DEVELOPMENT FACILITATION TEAM

Planning - Case Comments

Project Number: PR-2025-020158

Project Name: 1619 Solano Dr. NE

SKETCH PLAT FOR
LOTS 2A & 3A, BLOCK G,
ALTURA ADDITION
SITUATE WITHIN
SECTION 14, T.10 N., R.3 E., N.M.P.M.
CITY OF ALBUQUERQUE
BERNALILLO COUNTY, NEW MEXICO
NOVEMBER 2025

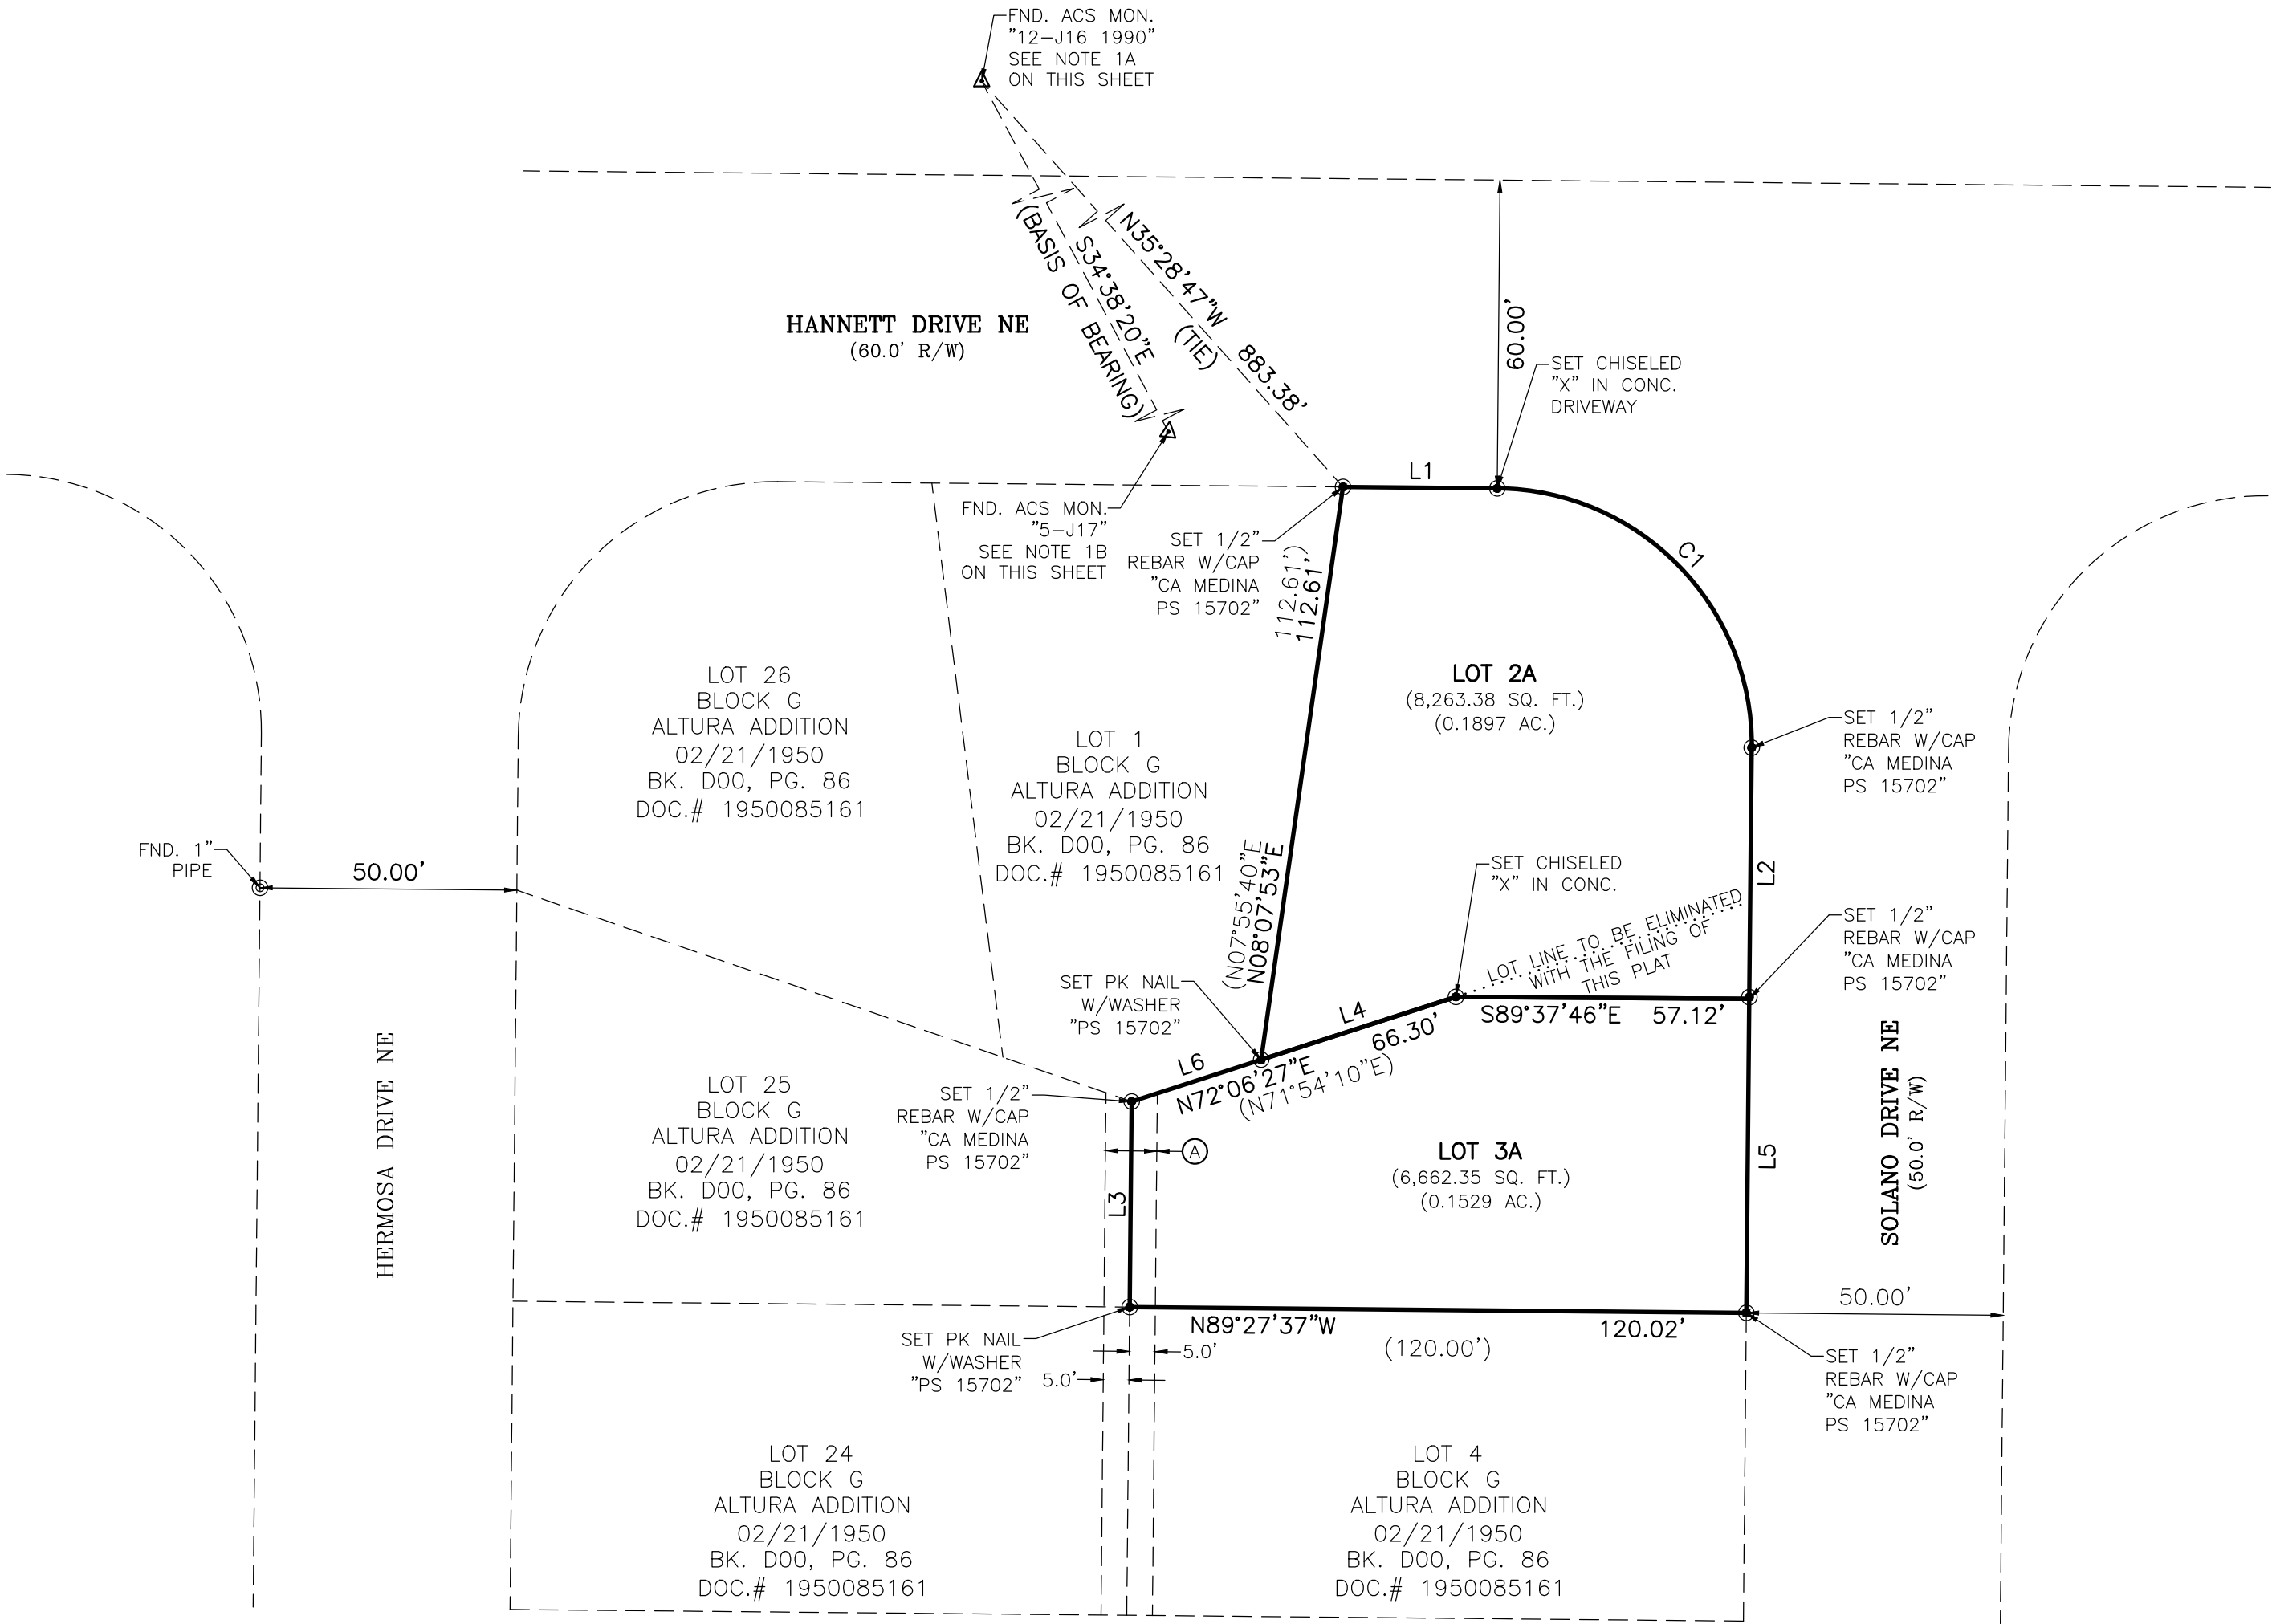
- The subject property is zoned R-1B (Residential – Single-Family Zone District) and falls within the Altura Addition Neighborhood Association.
- Demonstrate compliance with Section 7 of the **DPM, Table 7.2.29**, regarding Sidewalk width requirements and its landscape buffer. Both Solano Drive and Hannett Avenue NE are considered Local Streets and require a 5ft sidewalk width and a 4-6ft landscape buffer.
